From: Lisa Coney on behalf of Planning
Sent: 06 February 2017 08:54
To: Planning Scanning; Planning.Responses
Subject: FW: Planning Application FG/198/16/PL - OBJECTION - 1, Sea Drive, Ferring

Sent: 05 February 2017 13:45
To: Planning
Subject: Planning Application FG/198/16/PL - OBJECTION - 1, Sea Drive, Ferring

My name is Mrs Janice Royle of 108 Sea Lane, Ferring, West Sussex. This is the adjoining property in respect of the proposed development above.

BASEMENT FLOOR PLAN

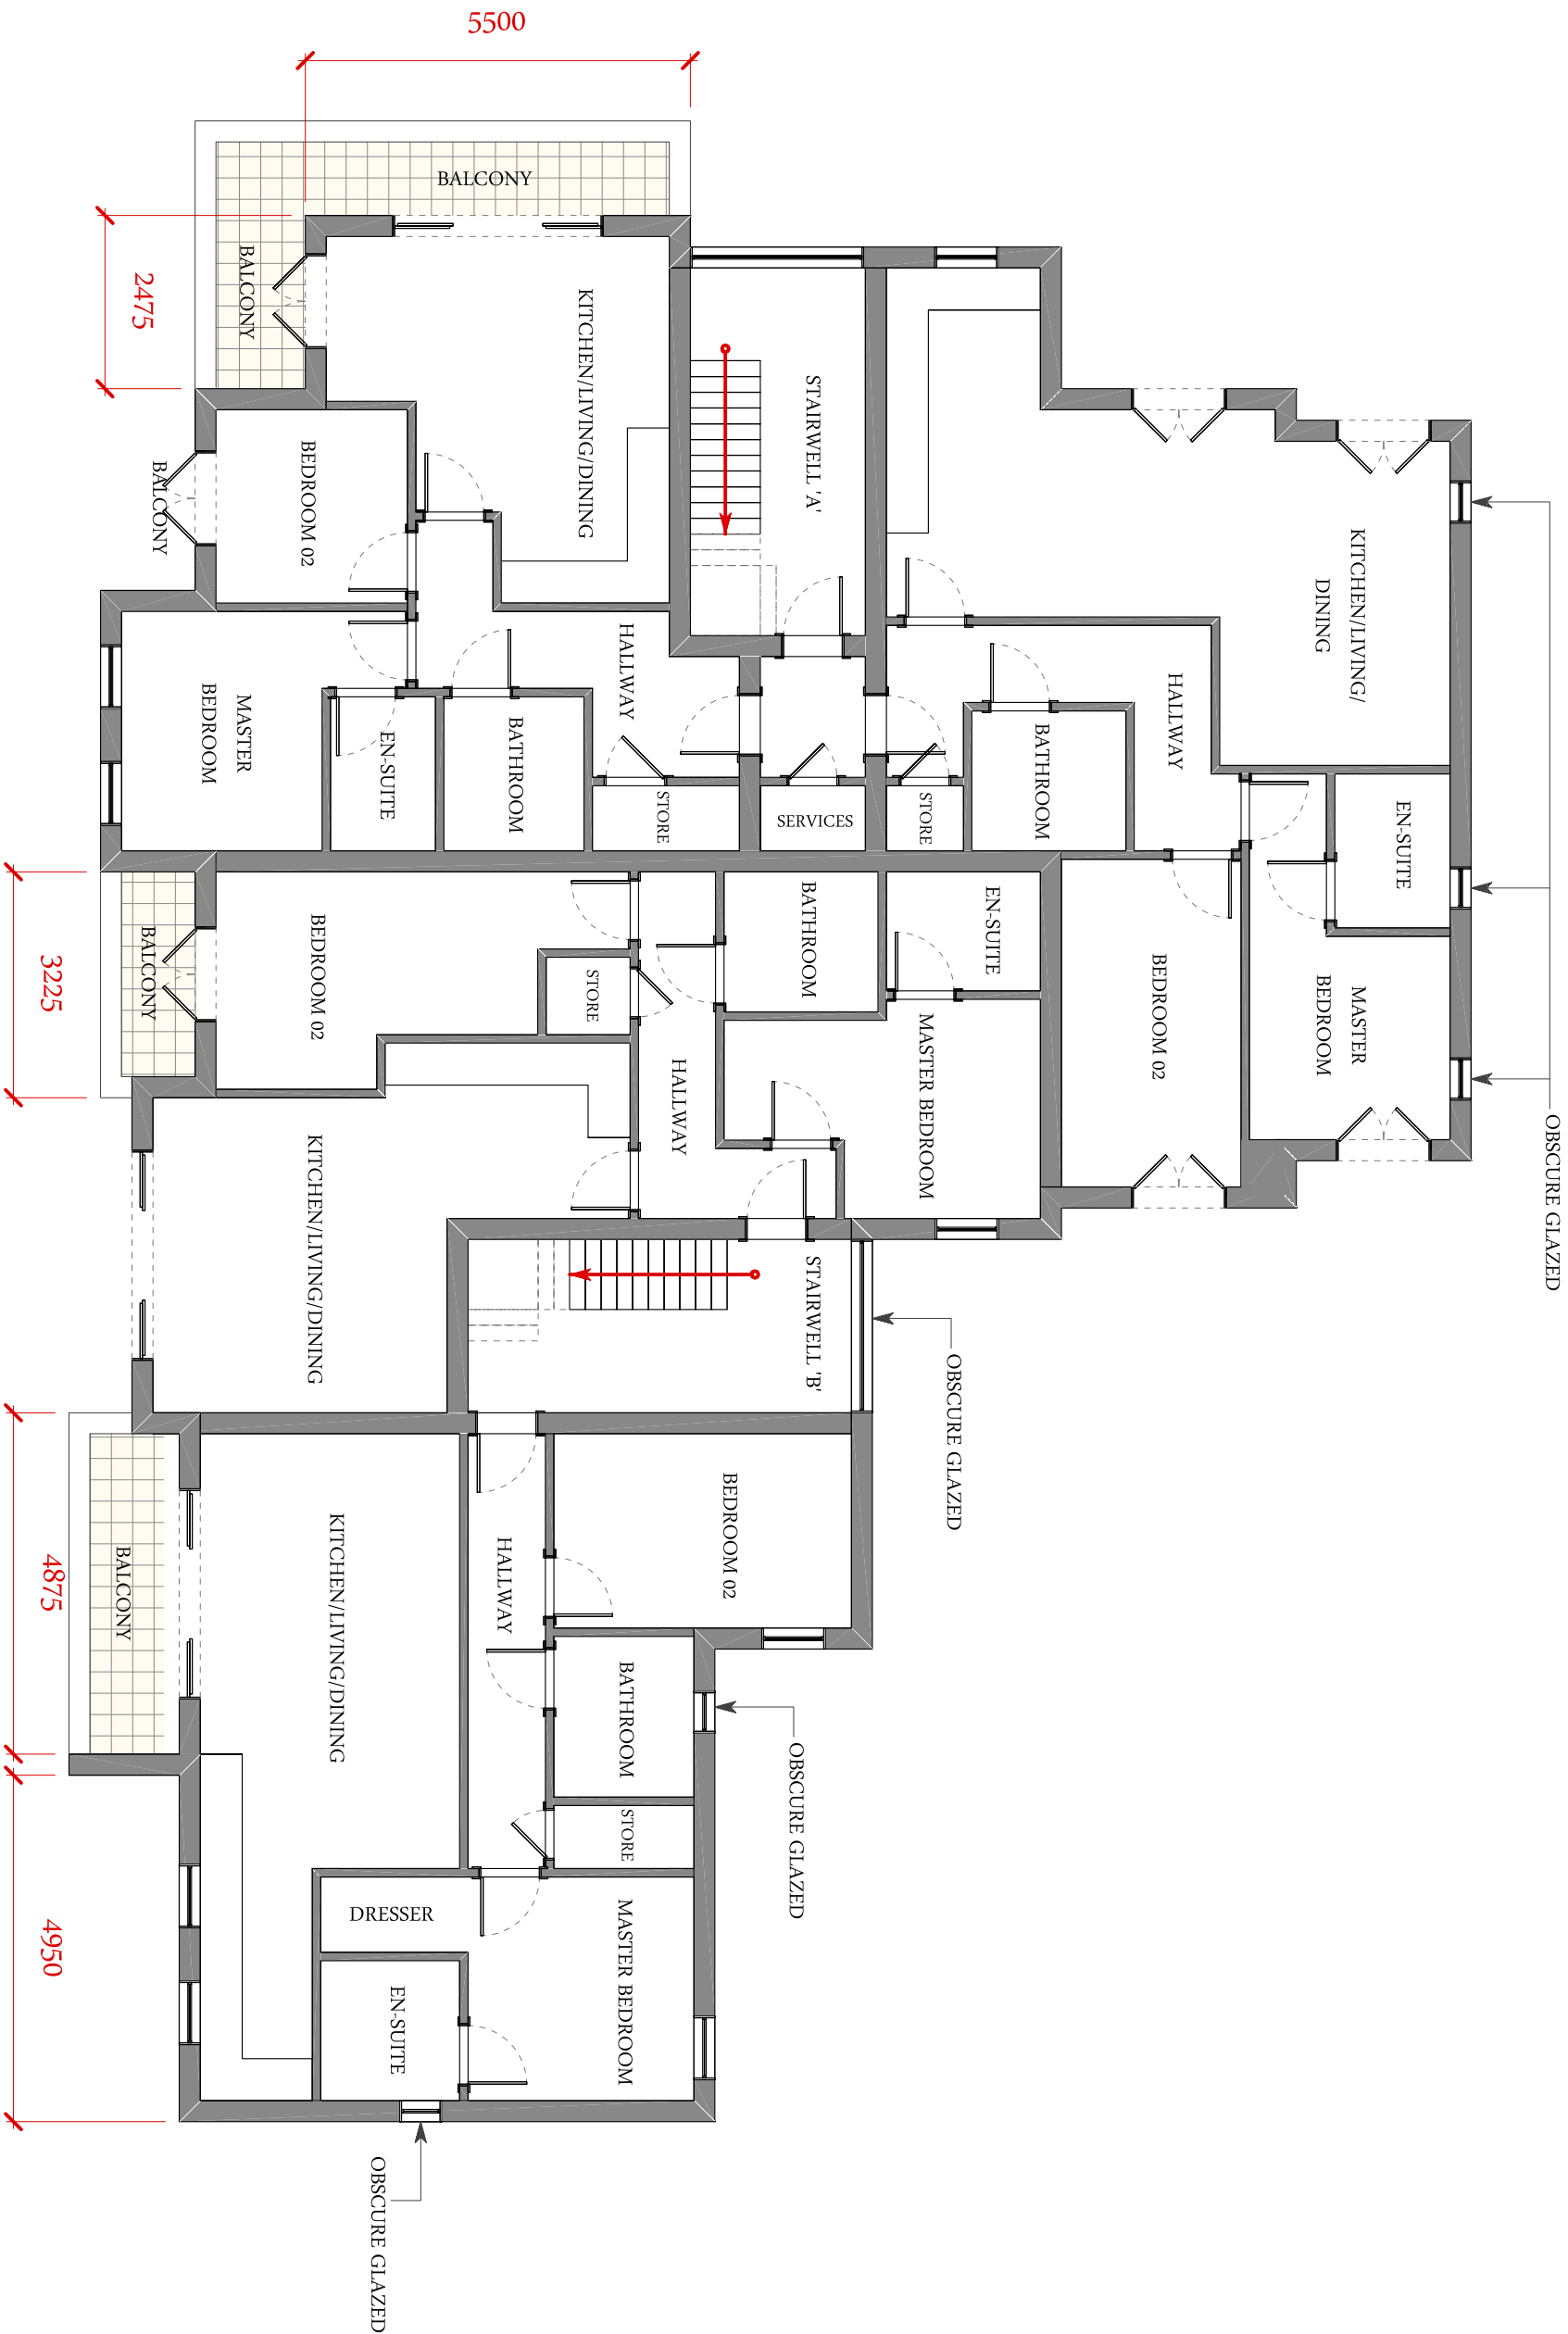
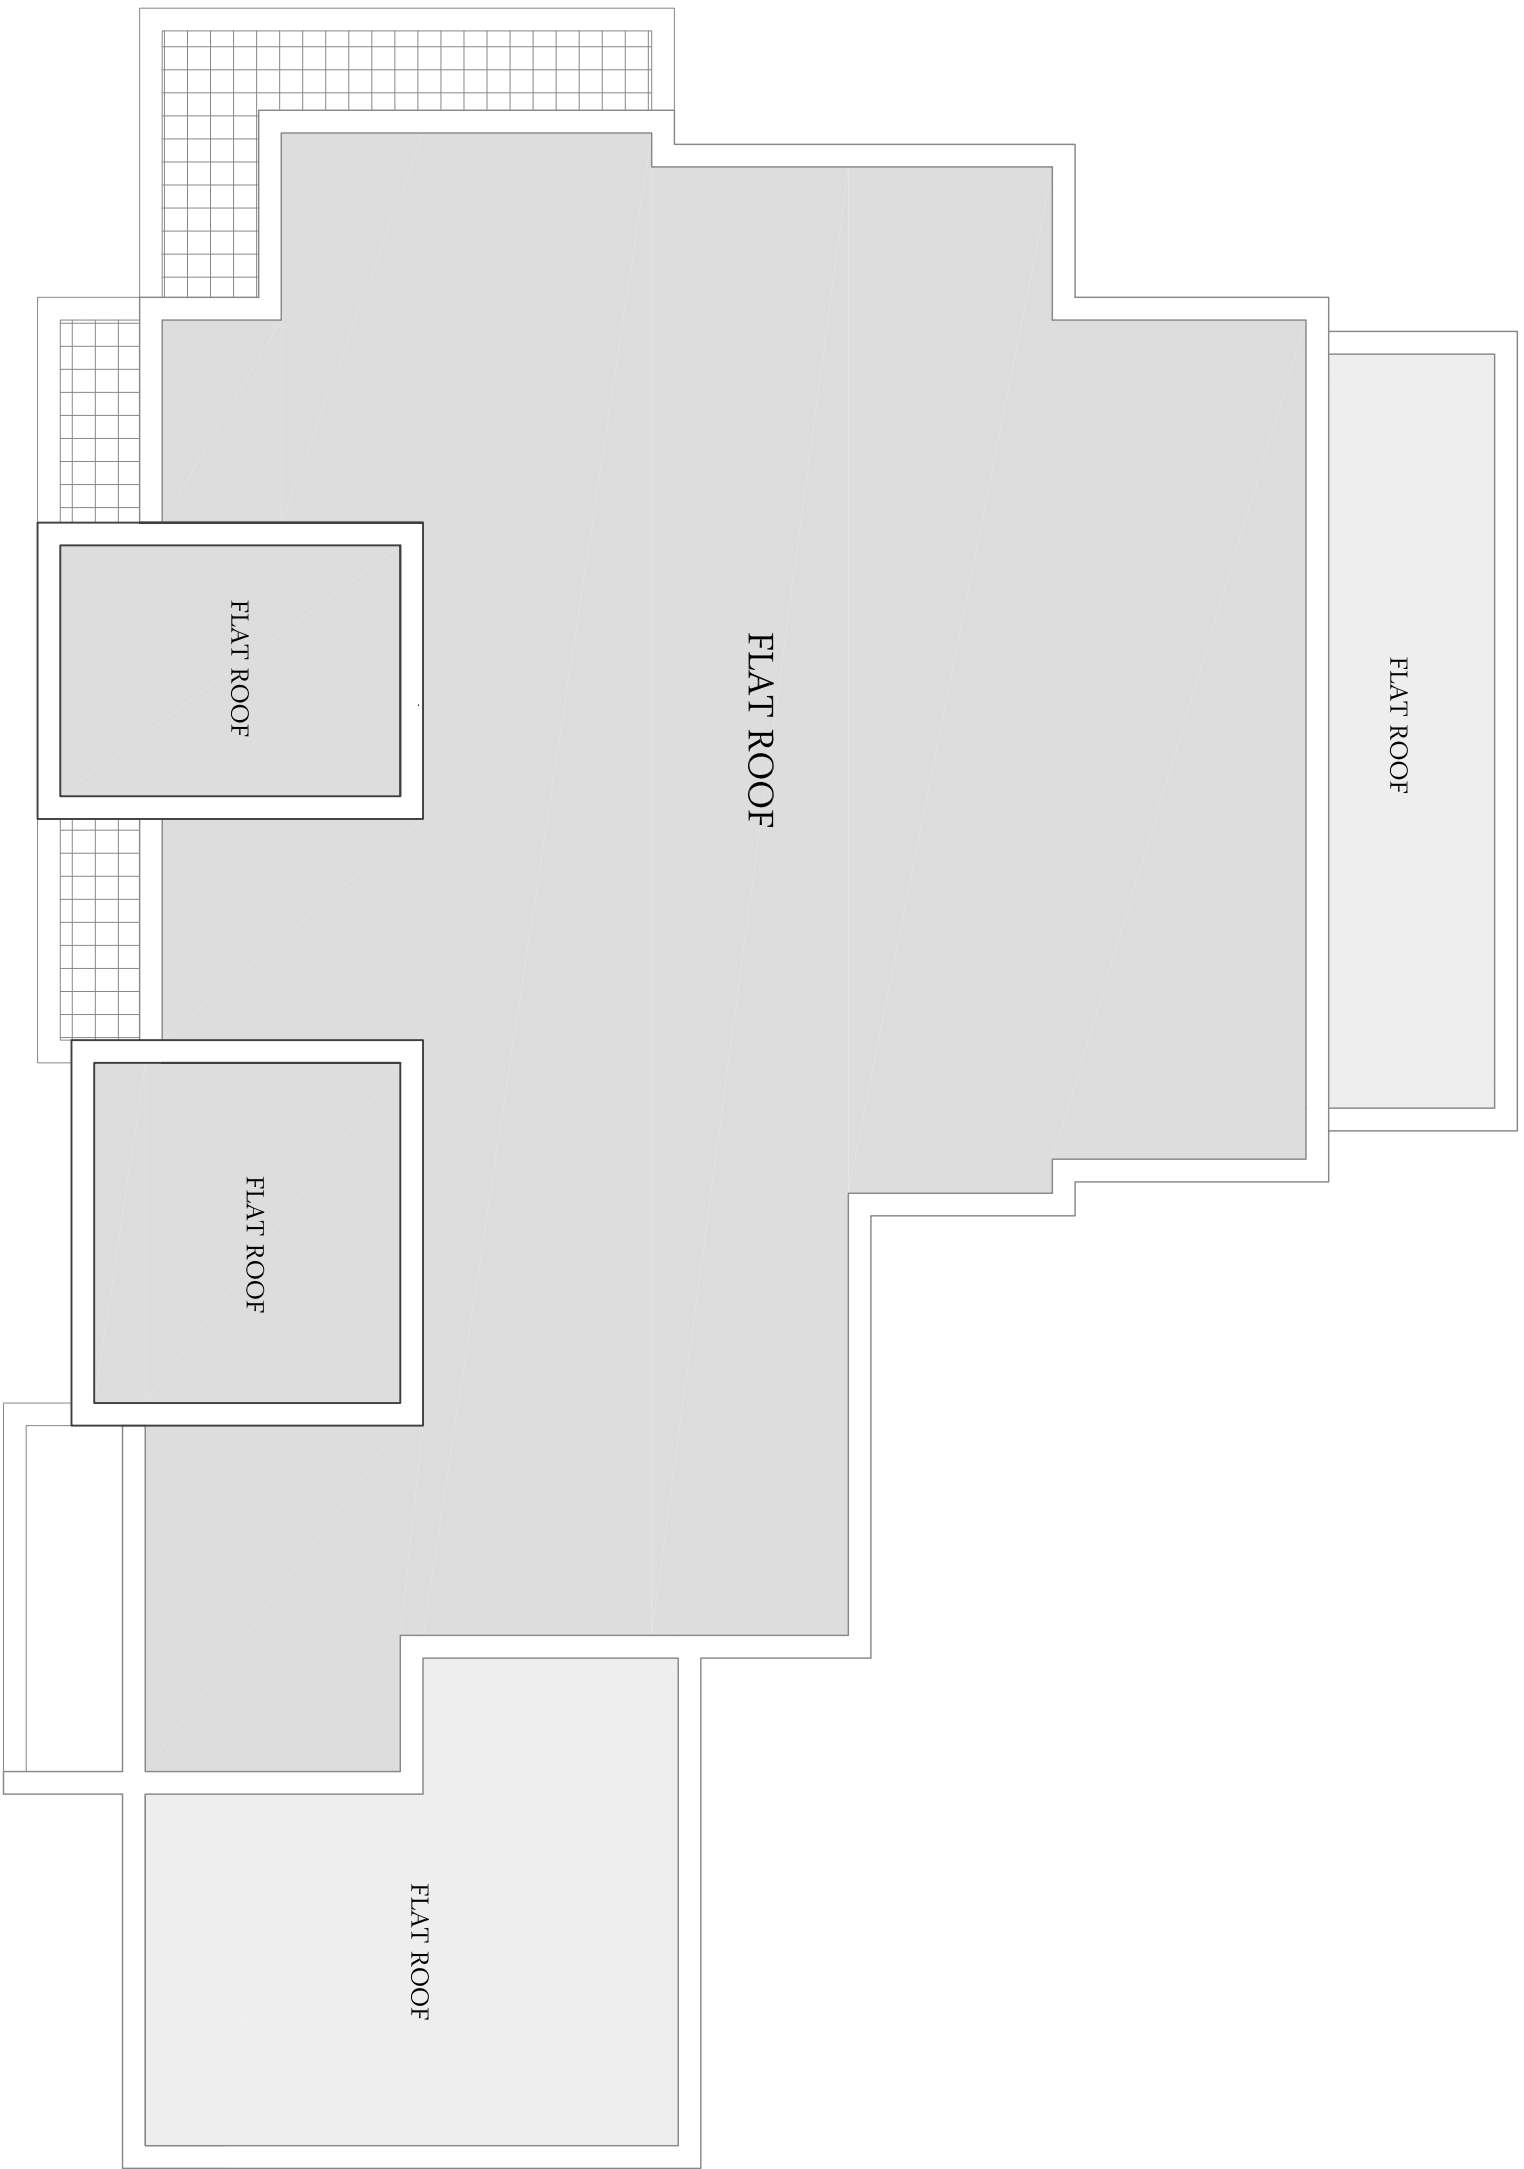
It is not in any way acceptable for the proposed construction to have a Master Bedroom window directly in line with my primary bedroom window where I spend a significant amount of my time. I vehemently object to this being the case.

I absolutely and most strongly object, to motor vehicles and motor bikes (for which provision has been made in said application) coming and going all hours of the day, and with headlights at night on full beam, directly under my bedroom window.

I strongly object to the proposal of a Bin Store under my main bedroom window and in close proximity to my lounge window and my rear doors.

I absolutely and utterly object to the ridiculous proposal of a new Highway Access onto Sea Lane, some three or four metres from my own driveway, on a complete blind spot.
